Engineers Comments Regarding Surface Water Drainage

Application Reference:	A/184/25/DOC	Reviewer Reference:	ADC/EXT5/AF
Planning Officer:	Harry Chalk	Date of Review:	23/12/2025
Site Name:	Land East of 22 Speedwell Chase Speedwell Chase Angmering		
Application Description:	Approval of details reserved by condition imposed under A/121/23/PL relating to condition 11-surface water drainage.		
Assessment Number:	1

Appendix 5

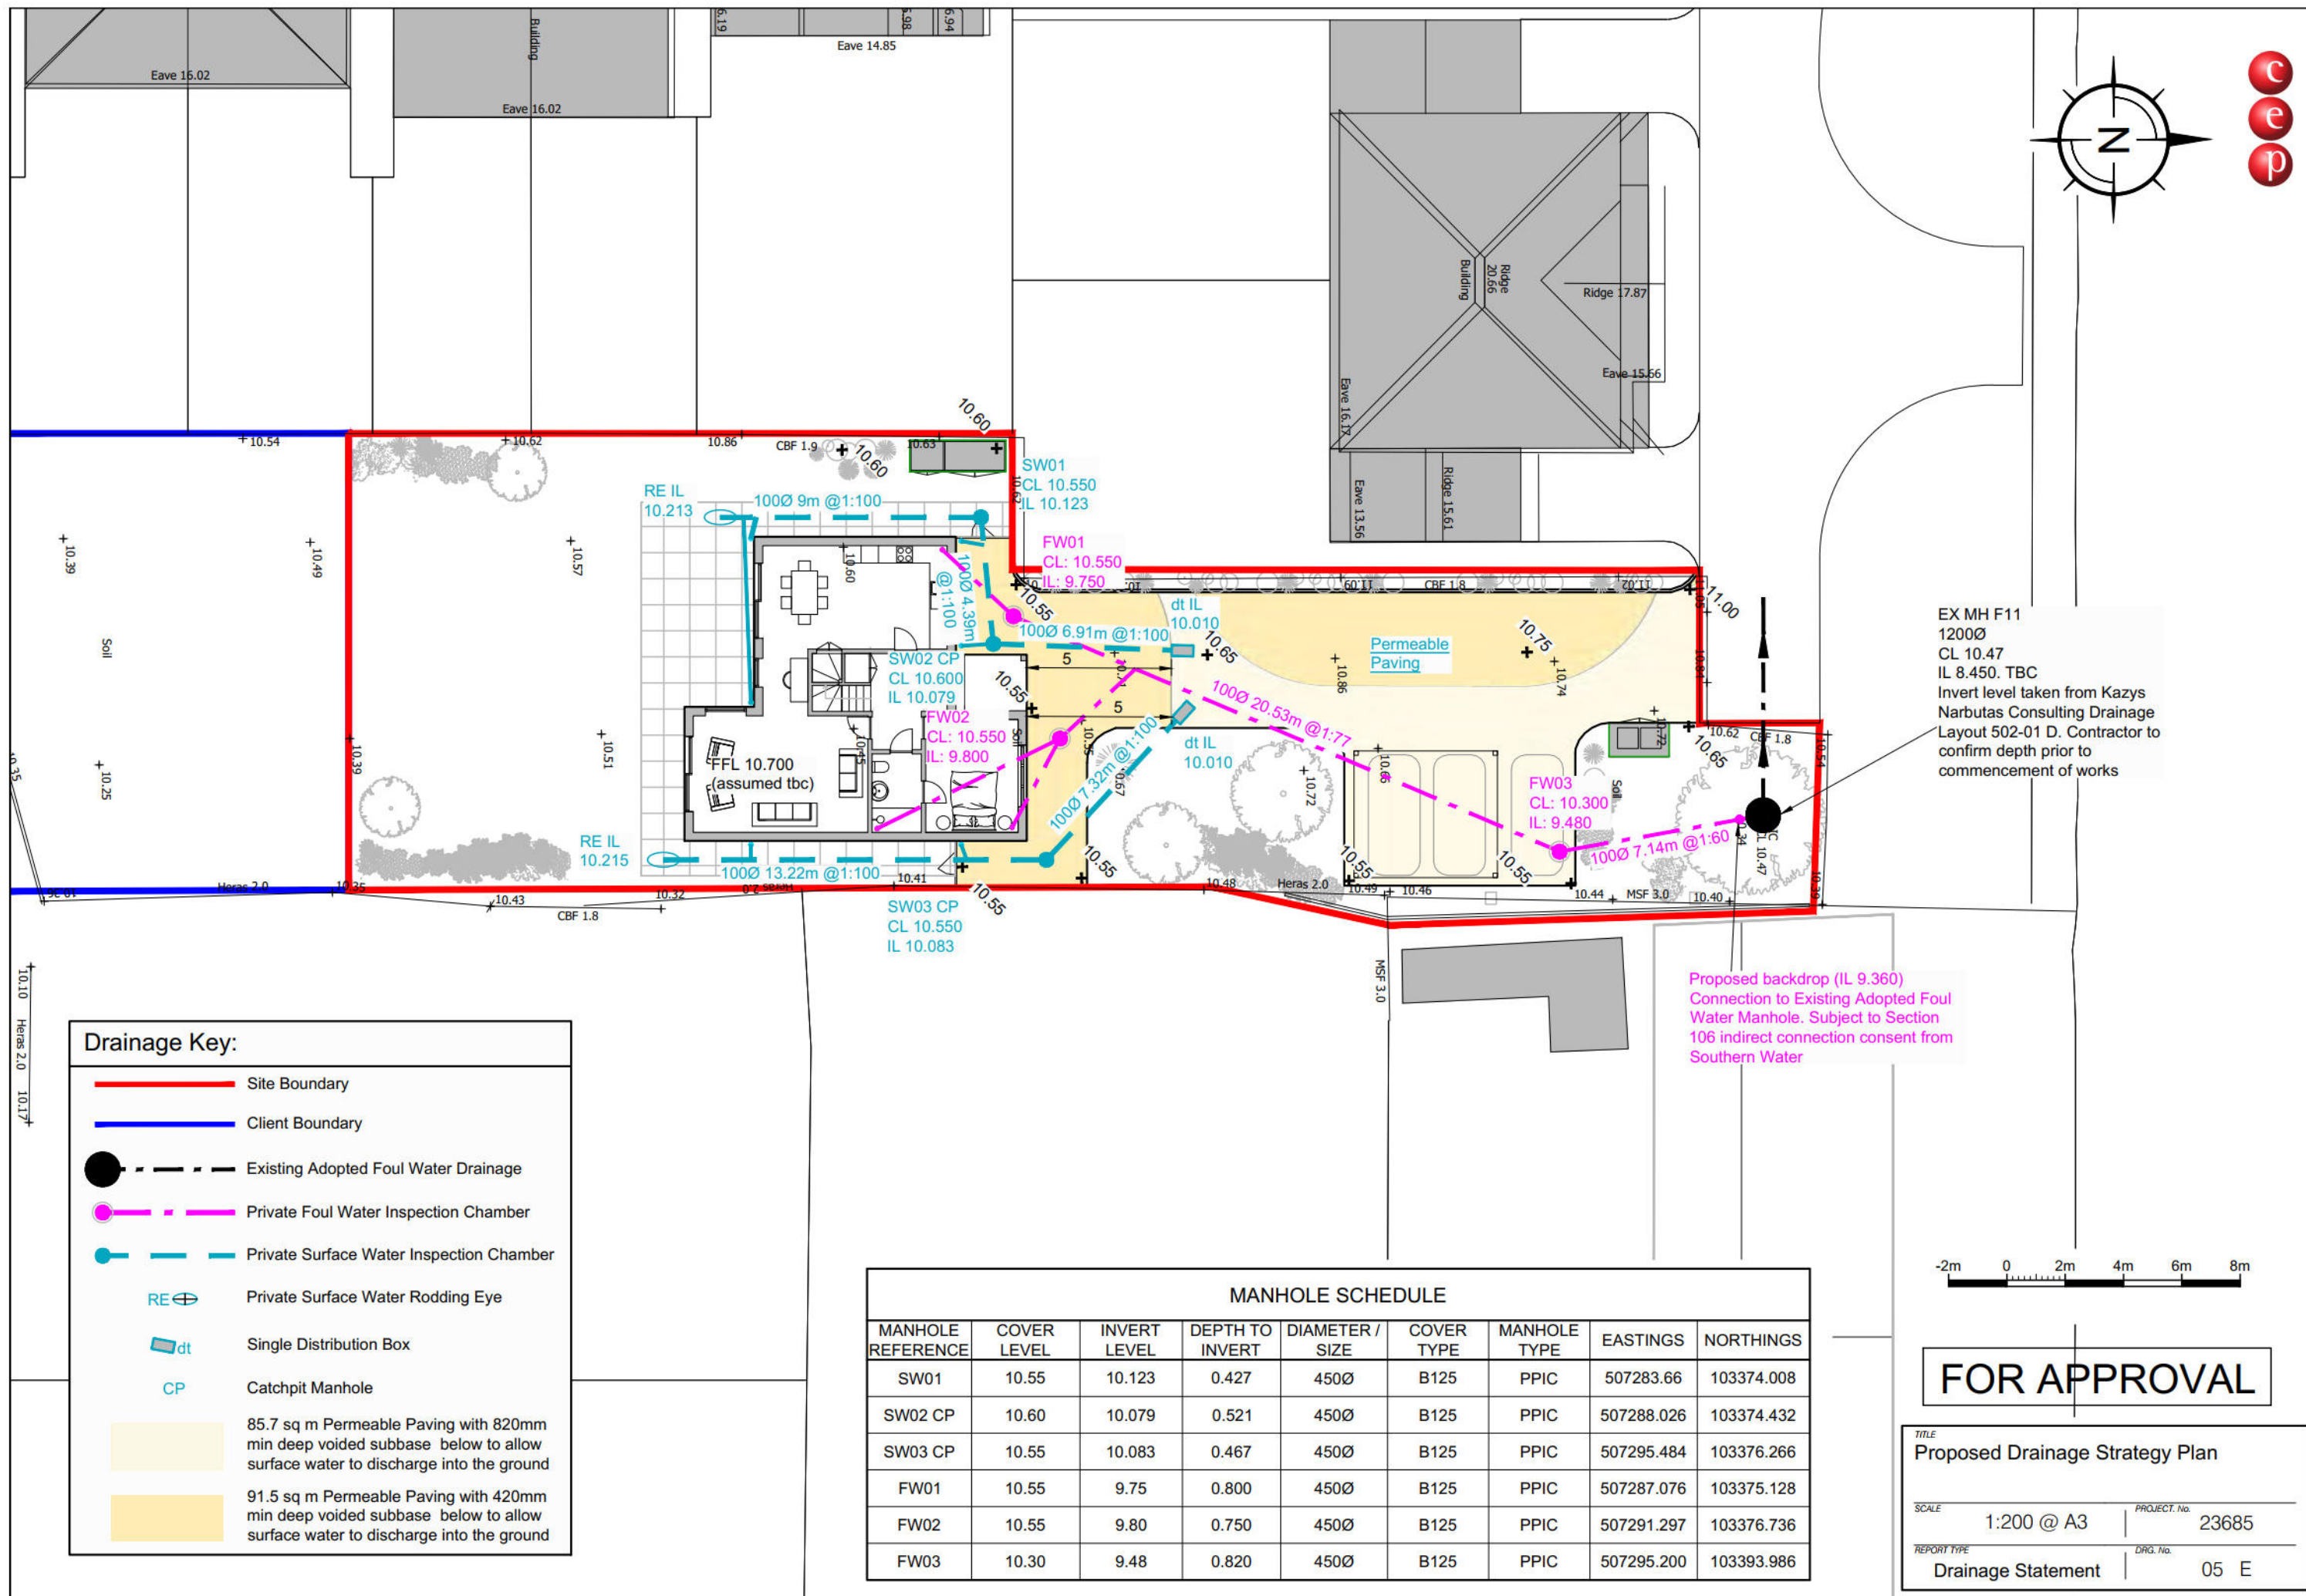
ADC Drainage Comments	Designer Response			
Date:	23/12/2025				
Condition Number: 11					
Comment Number					
1.	The factor of safety for the base infiltration rate should be increased in accordance with the NSfS.				
2.	The half drain time for the 3/3AEP+CCA storm should be demonstrated to be less than 24 hours based upon the entire drained area.				
3.	The drainage layout should show a Stage 4 Technical Design rather than Planning Strategy Plan and include full levels design. The layout should show the permeable pavement base levels rather than depths.				
4.	There is foul drainage shown conflicting with a proposed tree position, this should be

checked for viability of the proposed landscaping.				
5.	The MMP should be a final version standalone document and not interim attached to the discharge of conditions report. The drainage plans should be appended together with a proforma inspection and maintenance checklist.
